October 30, 2008

RE: J. Thomas Short Plat (SP-08-00031)

Kittitas County Community Development Services Department has determined that the J. Thomas Short Plat (SP-08-00031) is a complete application and hereby grants **conditional preliminary approval** subject to the following conditions:

J. THOMAS SHORT PLAT
 PTN. OF THE WEST 1/2 OF SECTION 7
 TOWNSHIP 21 NORTH, RANGE 13 EAST, W.M.
 KITTITAS COUNTY, WASHINGTON

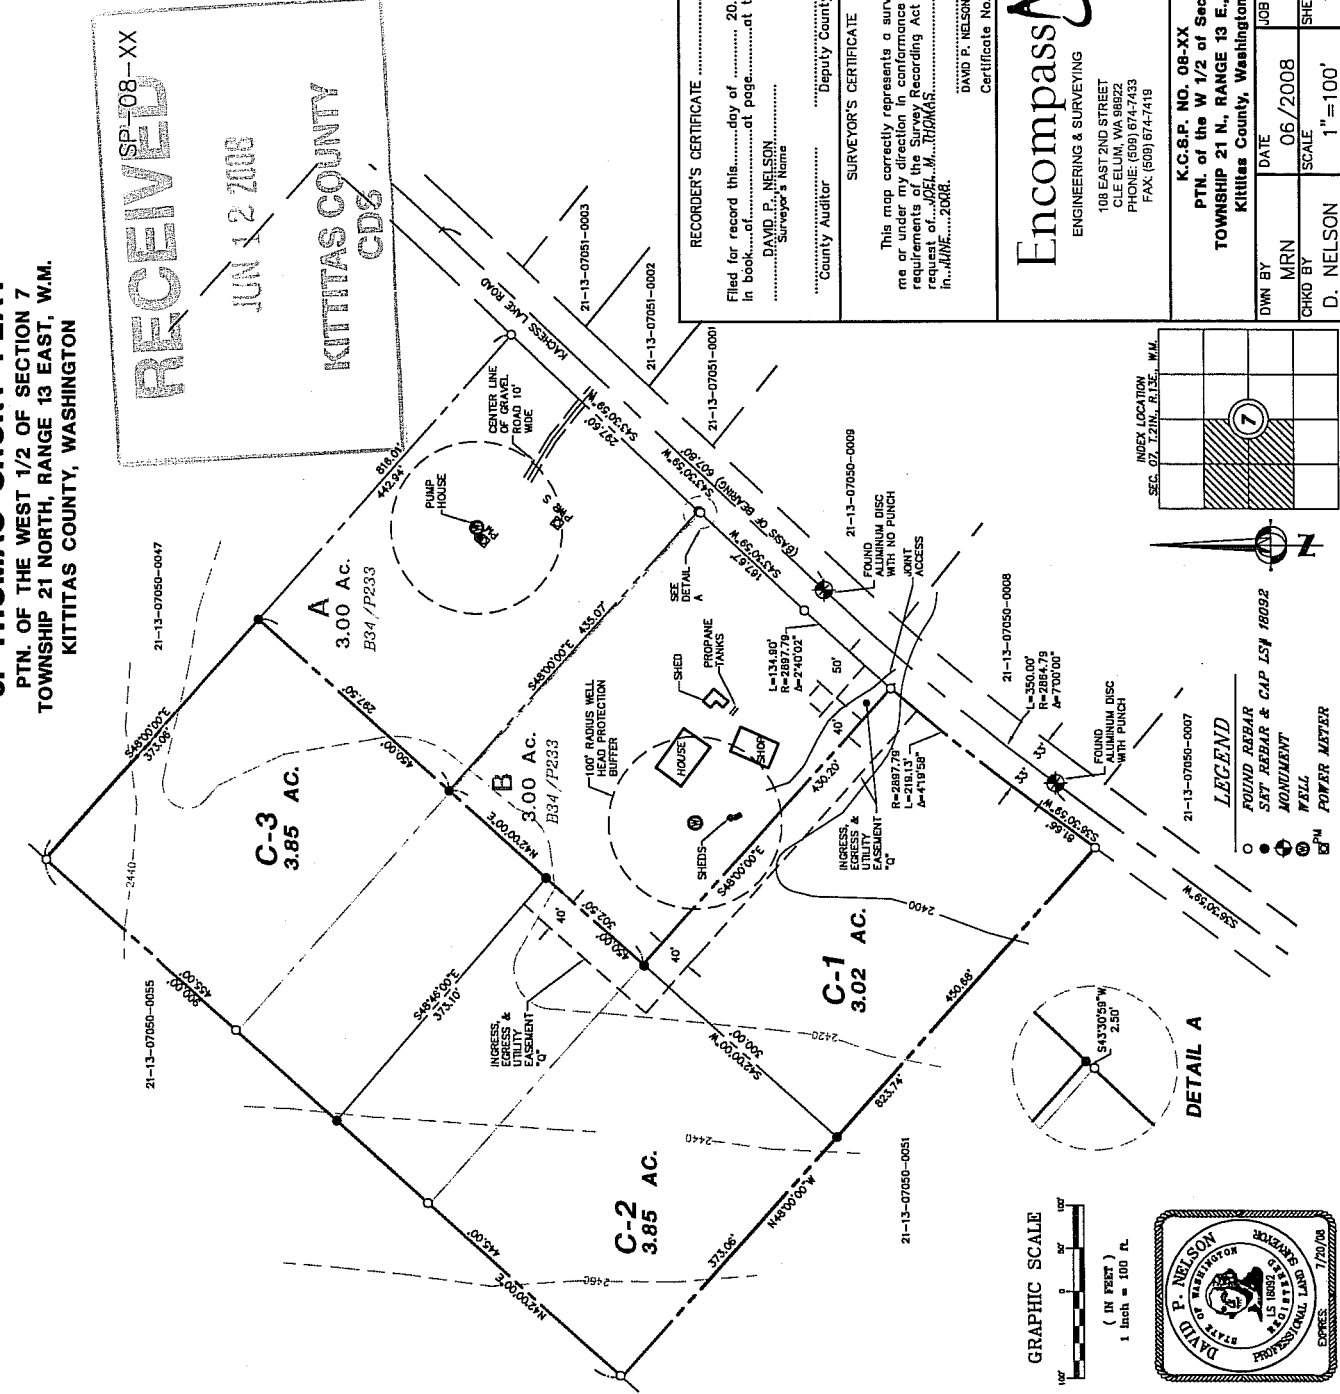
1. Both sheets of the final mylars shall reflect short plat number SP-08-00031 and an accurate legal description shall be shown on the face of the final plat.

10. Access: As shown on the preliminary plat, an individual access will be used to access Lot C-1, and a shared access will be used to access Lots C-2, C-3, and B. If access remains as shown, the access serving Lots C-2, C-3, and B shall be constructed as a high-density private road ending in a cul-de-sac and certified to meet the specifications shown below. If access points change, Public Works shall be permitted to re-review the short plat for access prior to final approval.

13. Private Road Improvements: Access shall be constructed to meet or exceed the requirements of a High-Density Private Road that serves 3-14 tax parcels. See Kittitas County Road Standards, 9/6/05 edition.

- a. Access easements shall be a minimum of 40' wide. The roadway shall have a minimum width of 20', with 1' shoulders, for a total width of 22'.
 - b. Minimum centerline radius will be 60'.

- c. Surface requirement is for a minimum gravel surface depth of 6".
 - d. Maximum grade 8% flat, 12% rolling or mountainous.
 - e. Stopping site distance, reference AASHTO.

14. Cul-de-Sac: A cul-de-sac turn-around having an outside right-of-way easement diameter of at least 110 feet shall be constructed at the closed end of all dead-end roads serving 3 or more lots. The driving surface shall be at least 96 feet in diameter. Cul-de-sacs must also conform to the requirements specified by the 2006 International Fire Code. Contact the Fire Marshal regarding any additional cul-de-sac requirements.
